Our Ref: 2023/92836

**TOWN AND COUNTRY PLANNING ACT 1990  
TOWN AND COUNTRY PLANNING (GENERAL PERMITTED DEVELOPMENT)  
(ENGLAND) ORDER 2015 (as amended), SCHEDULE 2, PART 3, PART MA  
NOTIFICATION OF PROPOSED CHANGE OF USE CLASS MA – COMMERCIAL,  
BUSINESS AND SERVICE USES TO DWELLINGHOUSES  
APPLICATION NUMBER: 2023/92836  
AT: 1st & 2nd floors, 9-13, Market Walk, Huddersfield, HD1 2QA**

**Prior approval of a proposed change of use of a building from commercial, business and service use to dwellinghouses**

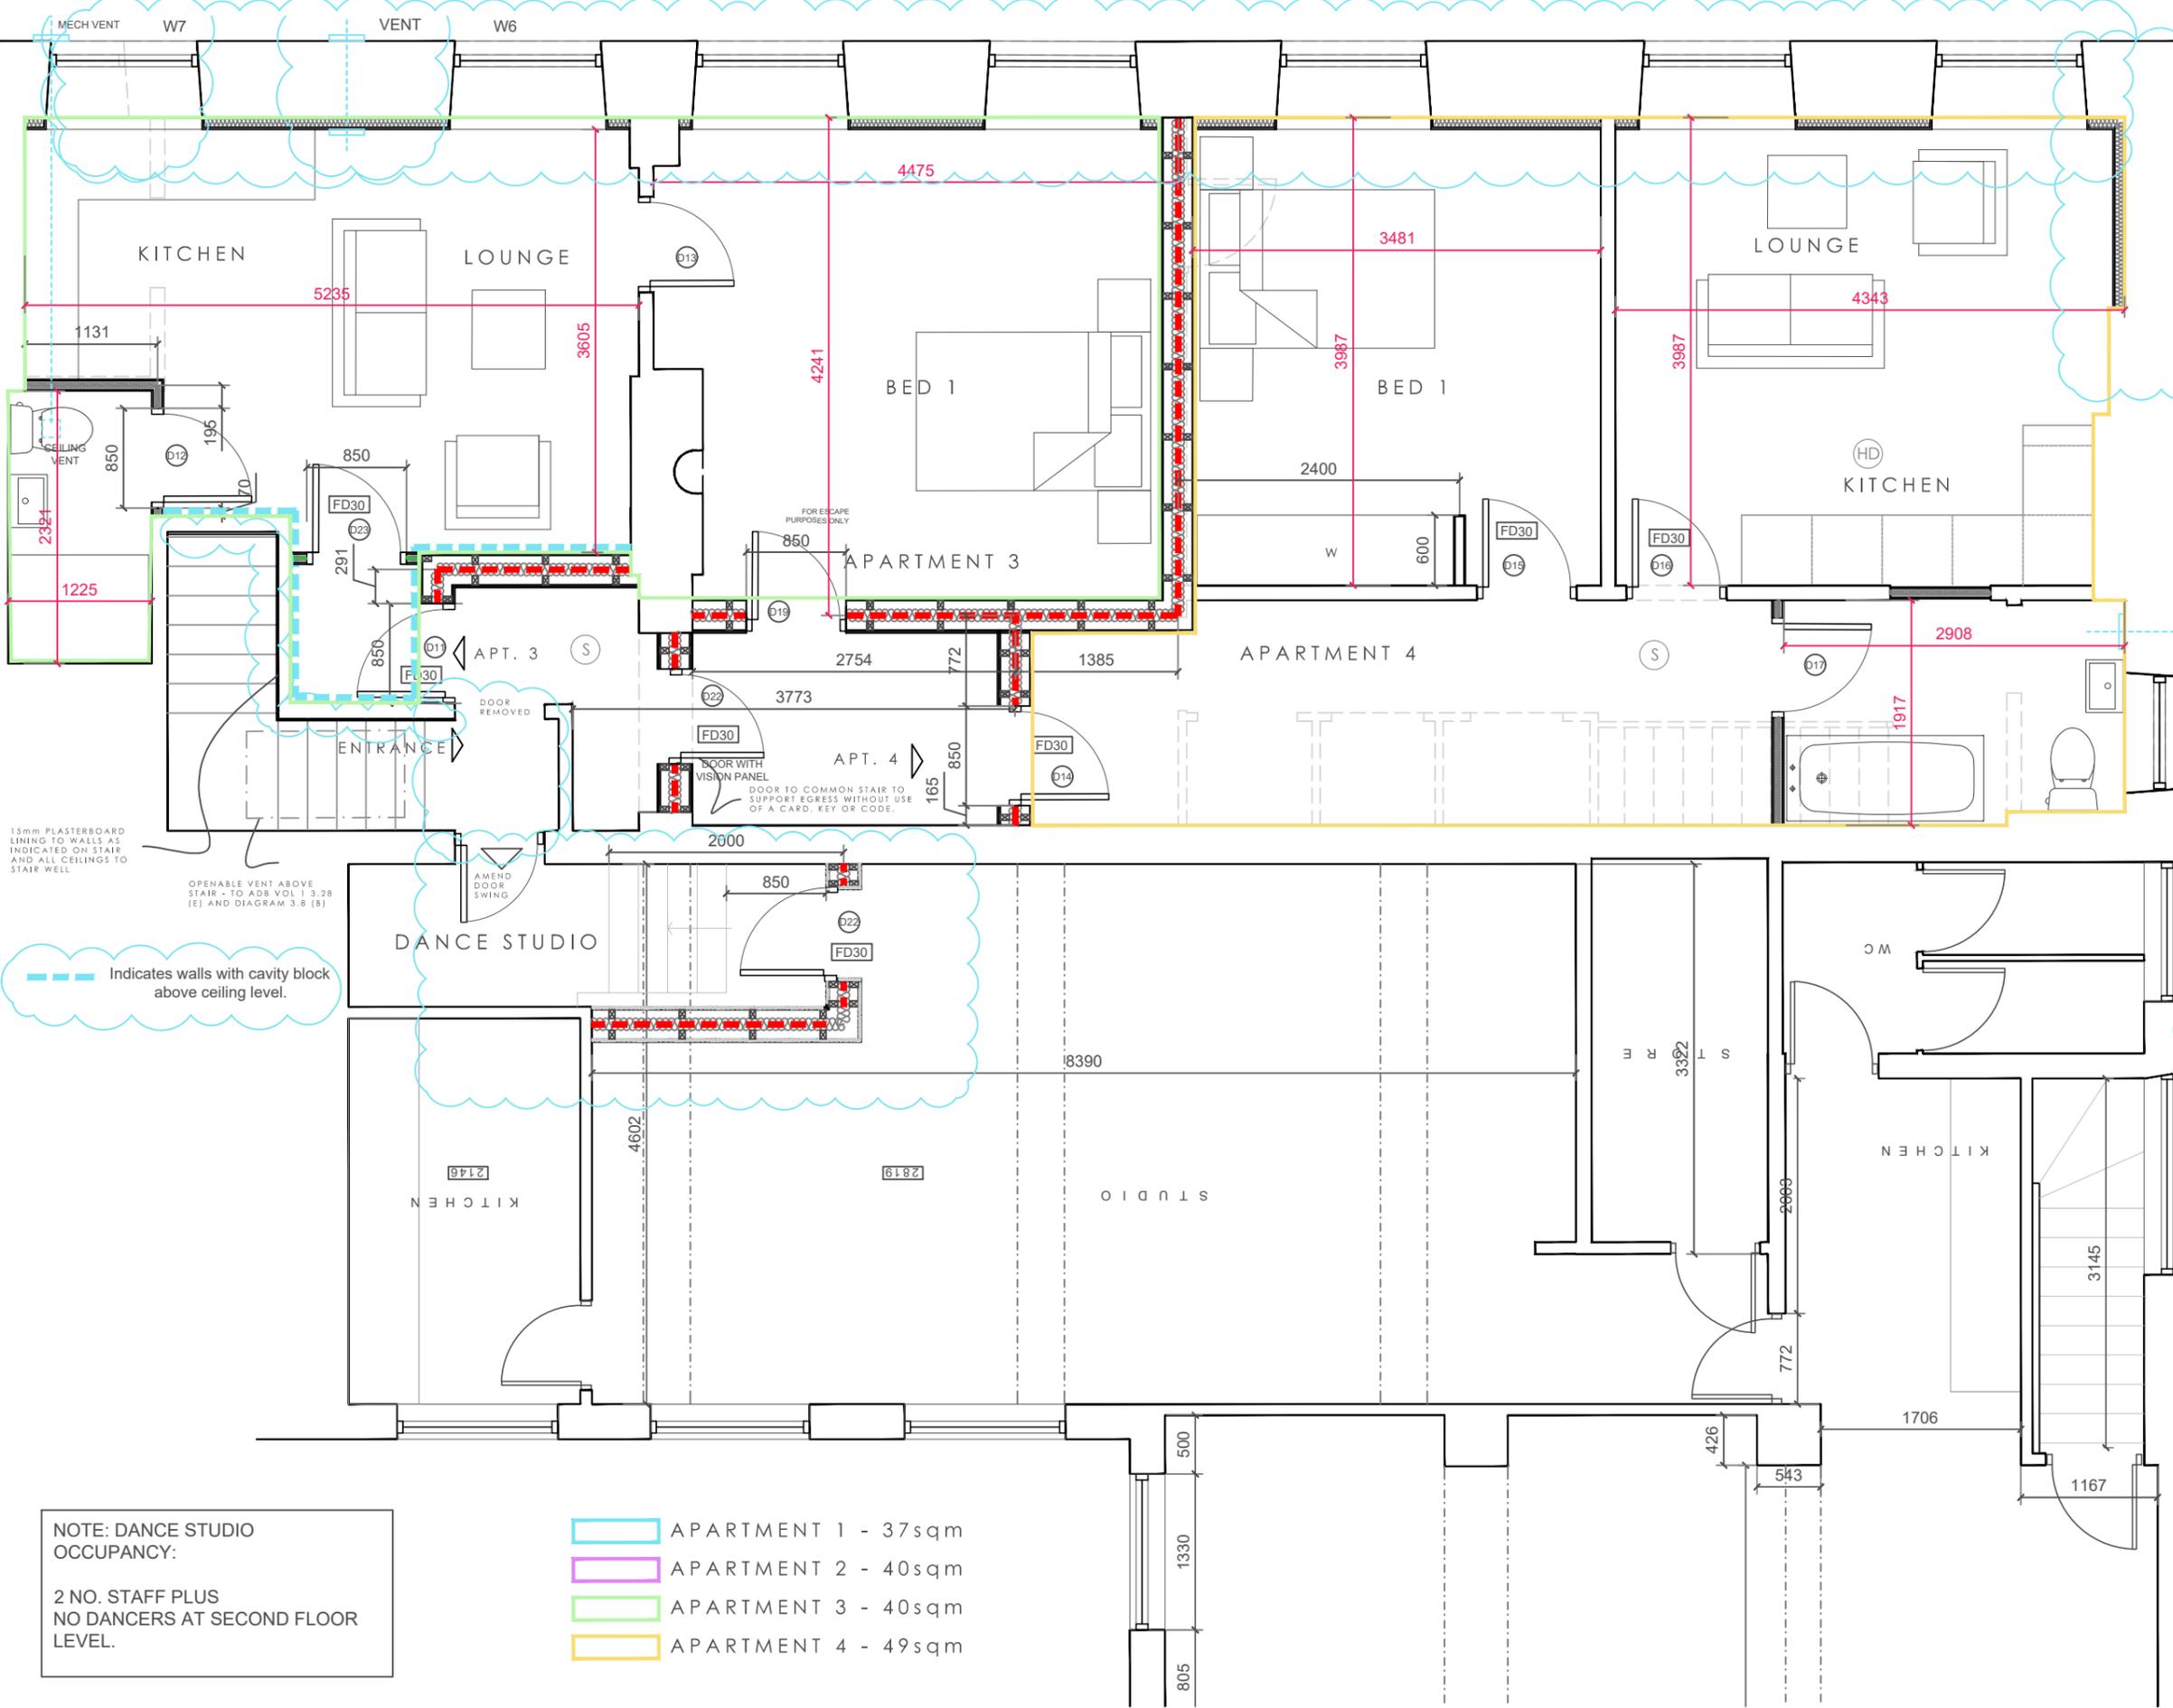
Apartment 3 is proposed to be a one bedroom second floor flat. The Technical Housing Standards document states that a one-bedroom flat for one person (minimum assessed) one storey should be at least 37 or 39 square metres dependant on whether the bathroom has a shower. In this instance, the internal accommodation is proposed to approximately 33.6 square metres which would not accord with the recommended space standards. However, the bedroom is shown to sleep two persons which requires 50 square metres of space, thus contrary to space standards.

Apartment 4 is proposed to be a one bedroom second floor flat. The Technical Housing Standards document states that a one-bedroom flat for one person (minimum assessed) one storey should be at least 37 or 39 square metres dependant on whether the bathroom has a shower. In this instance, the internal accommodation is proposed to approximately 41.3 square metres which would not accord with the recommended space standards. However, the bedroom is shown to sleep two persons which requires 50 square metres of space, thus contrary to space standards.
